**Planning Application No: 3/2026/0281**

**Proposal:** Demolition of existing dwelling and erection of one replacement self-build dwelling with garage and associated garden curtilage, hard and soft landscaping, new access drive off Longsight Rd and the closure of the existing access.

**Location:** Bridgecroft, Longsight Road, Copster Green BB1 9EX

Having reviewed the documents submitted Lancashire County Council acting as the highway authority makes the following initial comments and requests further information.

2 PROPOSED SITE PLAN - PLANNING
1: 500

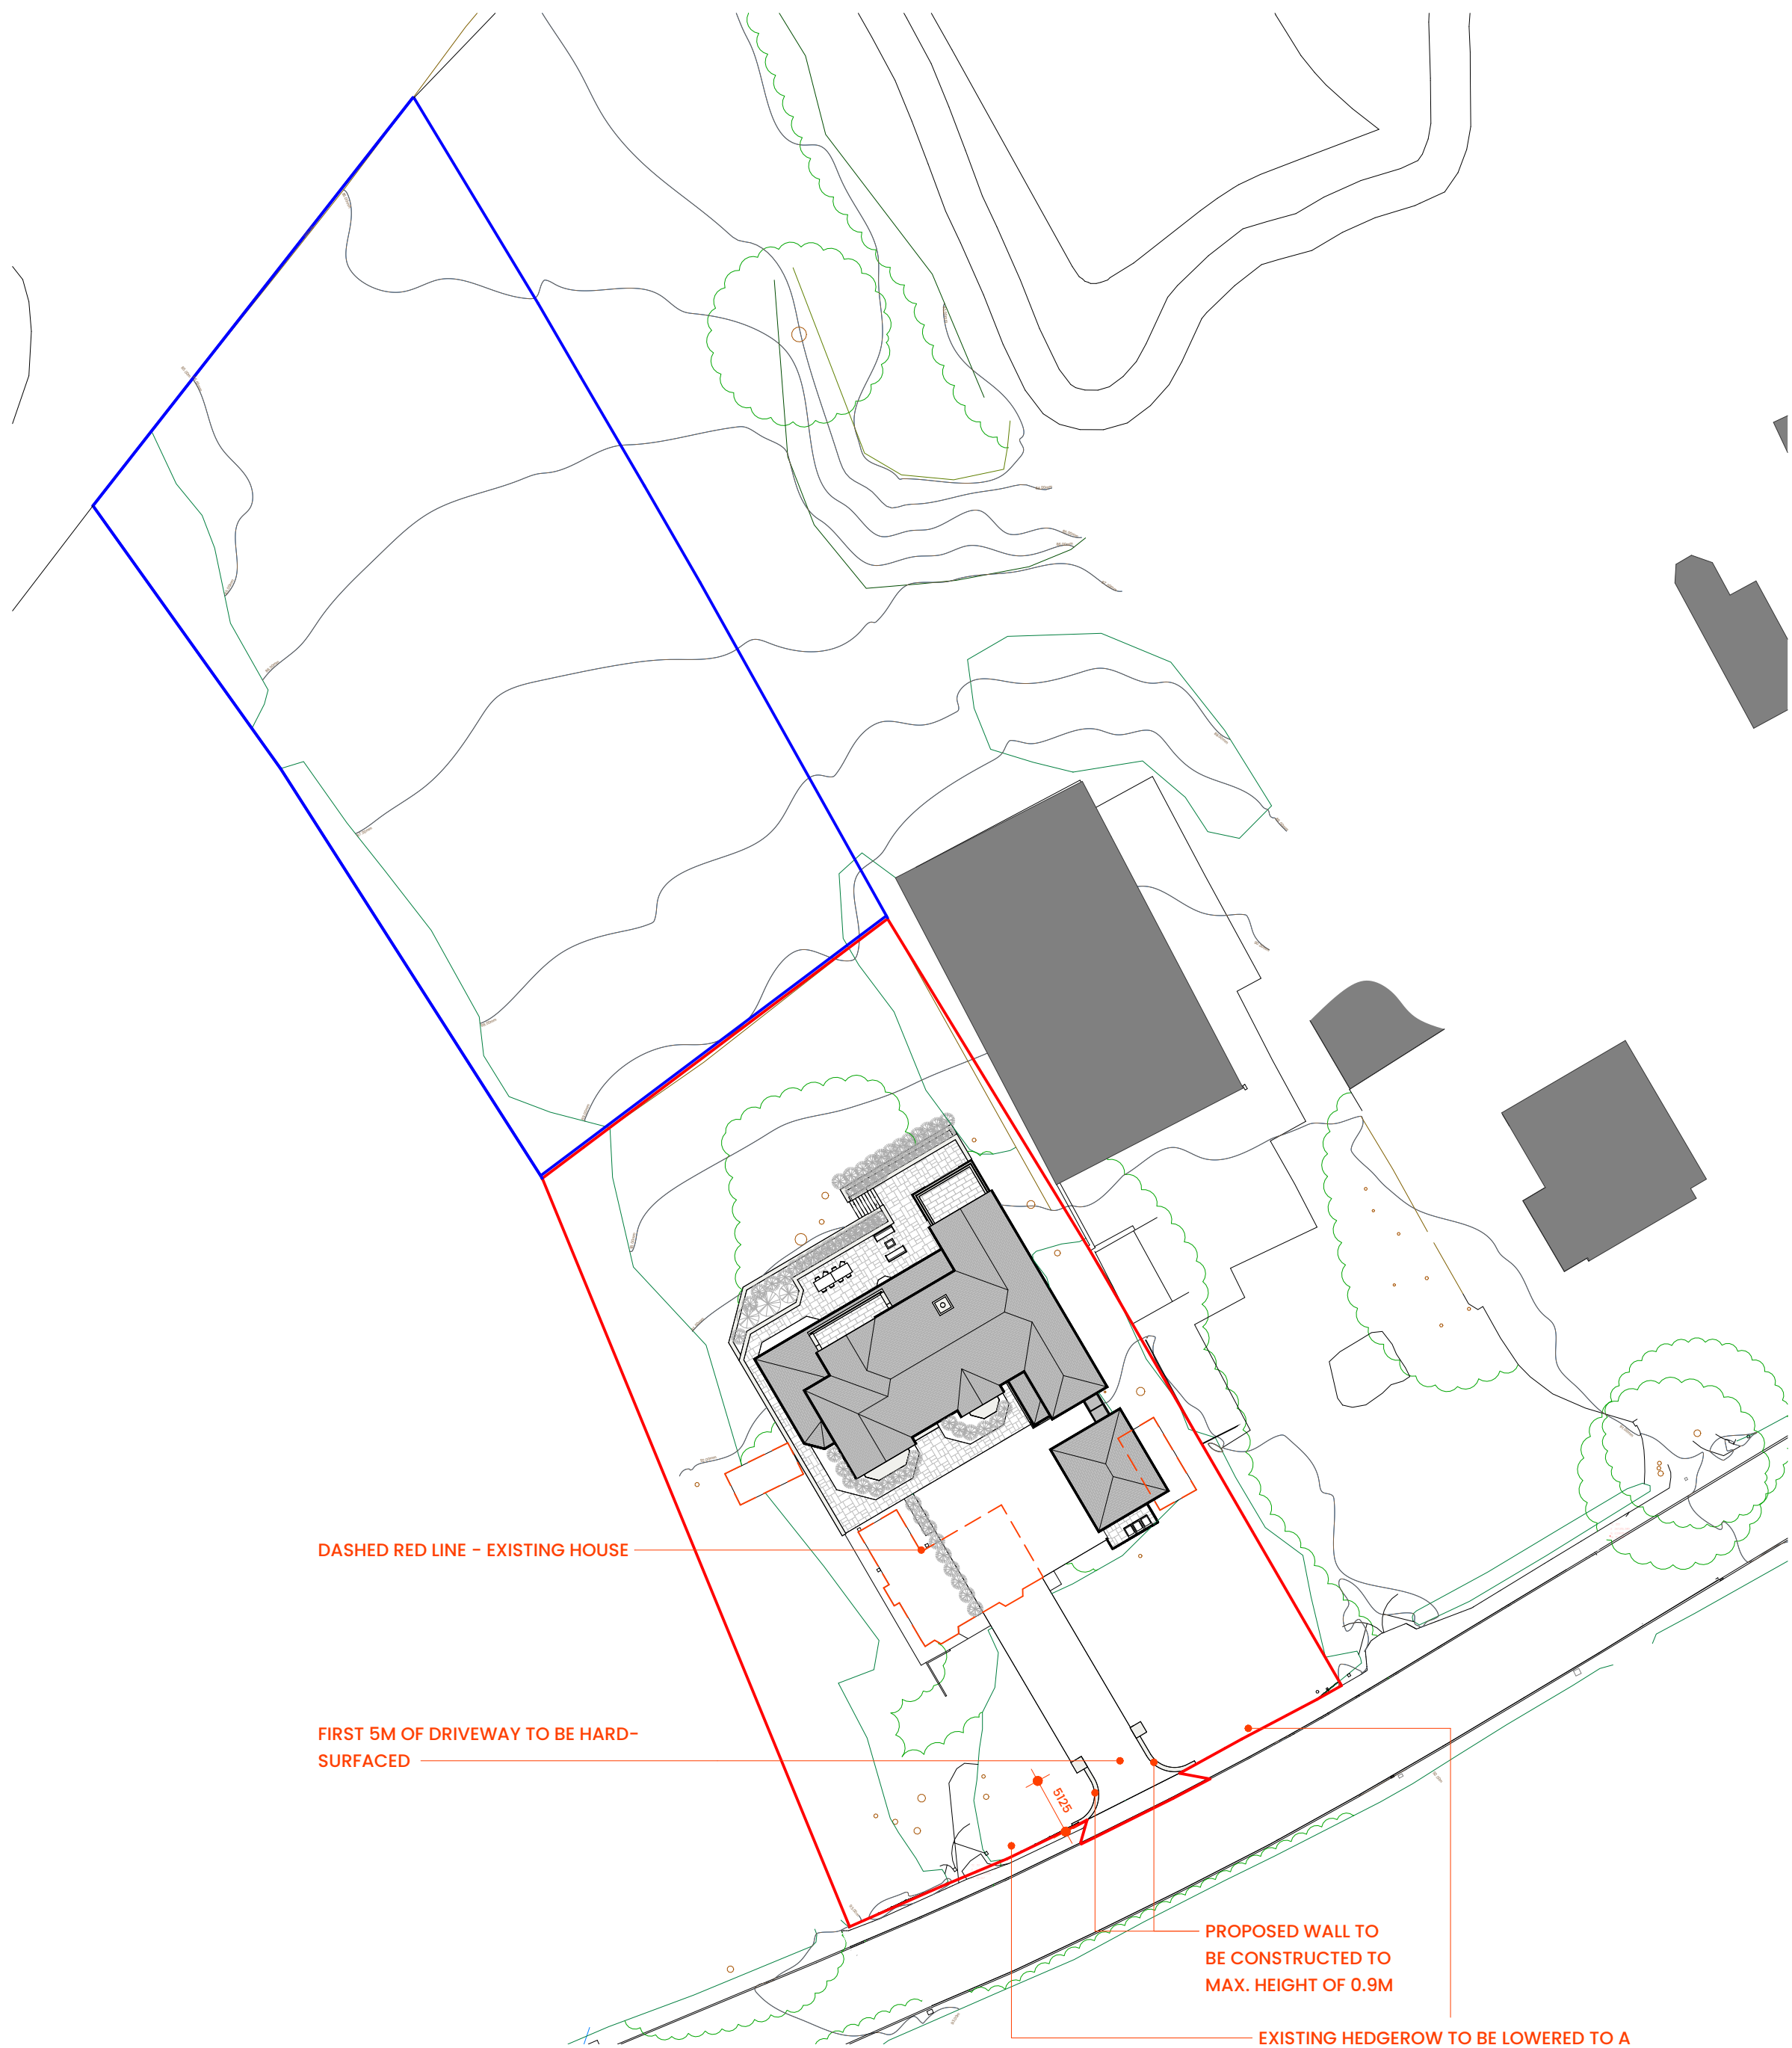
The first 5m from the back of the footway into the site should be a minimum of 5m wide to allow two vehicles to pass within the entrance to prevent vehicles from waiting on the carriageway, where they could pose a hazard or obstruction to other highway users. The plans need amending to reflect this.

For a road with a speed limit of 40mph a Stopping Sight Distance (SSD) – or visibility splays - of 120m should be provided in both directions from the new access. Visibility splays should be measured from a point 2.4m back along the centre line of the new access and to the nearside carriageway edge on Longsight Road. Nothing over 0.9m in height above the carriageway level should be within the visibility splays. This includes any sections of the proposed new stone wall. The railings on top of this wall should also be

The applicant has not provided any details of visibility splays onto Longsight Road. Traffic may be travelling below the maximum speed limit, and shorter visibility splays may be accepted. However this would need to be supported through data obtained by an automated seven day survey carried out in a neutral month, avoiding school holidays, national holidays and events, or local events which could impact on traffic movements and with prevailing weather conditions noted.

Whilst the re-location of the access more centrally to the plot may provide improved visibility to that from the existing access, adequate visibility splays as outlined above will still need to be demonstrated/provided as there will be an increase in vehicle movements from those generated by the existing two bed dwelling.

A suitably scaled drawing demonstrating that adequate visibility splays can be achieved from the new access should be submitted. This should also include the correct geometry of the road layout.

If appropriately scaled drawings and plans are submitted which demonstrate that the necessary visibility splays can be achieved over land within the applicant's ownership and/or the highway network maintained at public expense then the highway authority will review its comments and may consider withdrawing its objection. A plan showing the widened access should also be submitted.
